Appeal Decision

Appeal Ref: APP/R5510/D/21/3269679
13 Foxdell Northwood HA6 2BU

- The appeal is made under section 78 of the Town and Country Planning Act 1990 against a refusal to grant planning permission.
 - The appeal is made by Mr Christian Bodtke-Monal against the decision of the Council of the London Borough of Hillingdon.
 - The application Ref.72654/APP/2020/3132, dated 1 October 2020, was refused by notice dated 3 December 2020.
 - The development proposed is a two storey side extension, hip to gable roof conversion, insertion of 3 rear facing dormers, 5 front facing roof lights plus high level below apex side window.
-

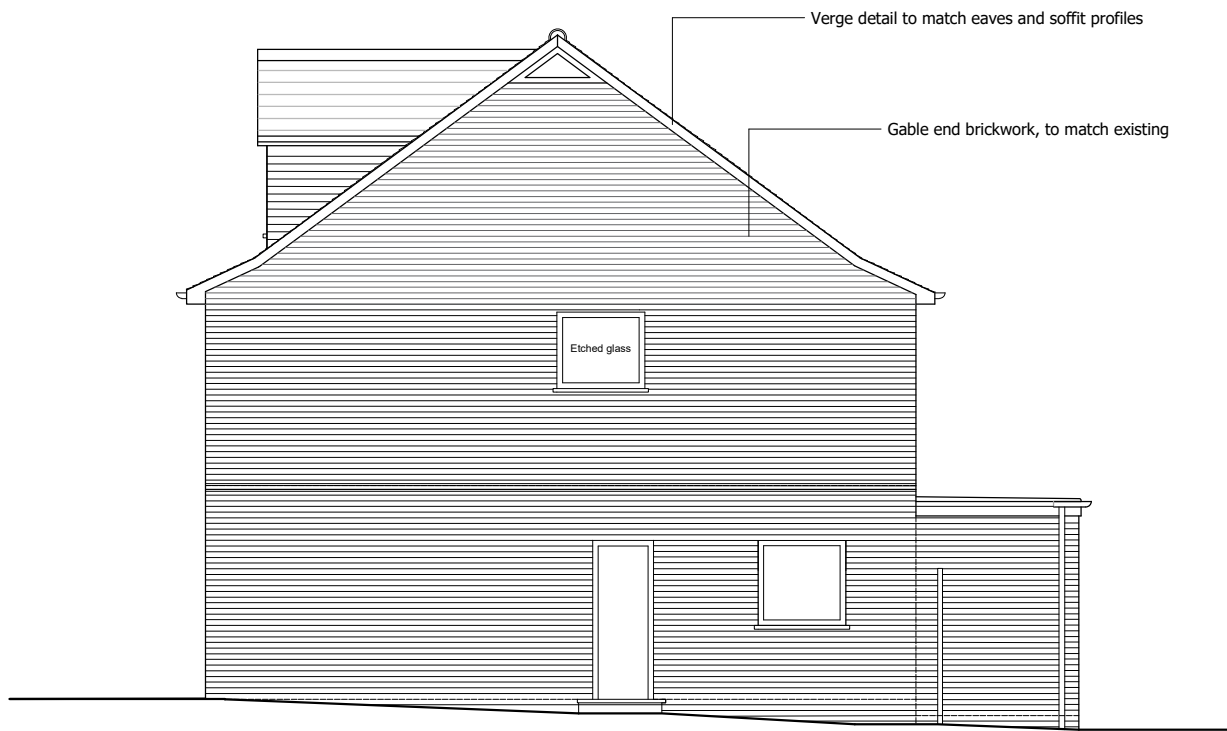
4. The appeal property (No 13) is located at the end of Foxdell, a short cul-de-sac consisting of large detached dwellings. Some of these dwellings have been subject to extensions and alterations though these have not significantly changed the overall character and appearance of the area. The area retains a well balanced appearance and character of detached properties in a mature setting.
5. Whilst the side extension proposed is modest in itself, the construction of gable walls to enable the proposed roof conversion would result in a sizeable addition to No 13. Together they would appear disproportionate and unsympathetic and add considerably to the bulk and scale of the dwelling. The gable walls would

result in a mass of built form which would be dominant in the street scene. In addition, the introduction of a number of roof lights within an extended roofscape would be an incongruous addition drawing the eye and resulting in harm to the character and appearance of the area when viewed in the context of the cul-de-sac.

8. I therefore conclude that the development would result in unacceptable harm to the character and appearance of No 13 and the area. As such the development is contrary to Policy BE1 of the Hillingdon Local Plan: Part One – Strategic Policies (November 2012), and Policies DMHD1, DMHD11 and DMHD12 of the Hillingdon Local Plan: Part Two – Development Management Policies (2020) which together require development to be of a high quality design to harmonise with the local context, for extensions to appear subordinate to the main dwelling and be well integrated with no adverse cumulative impact on the character of the area. It would also conflict with the National Planning Policy Framework which requires development to be sympathetic to local character.
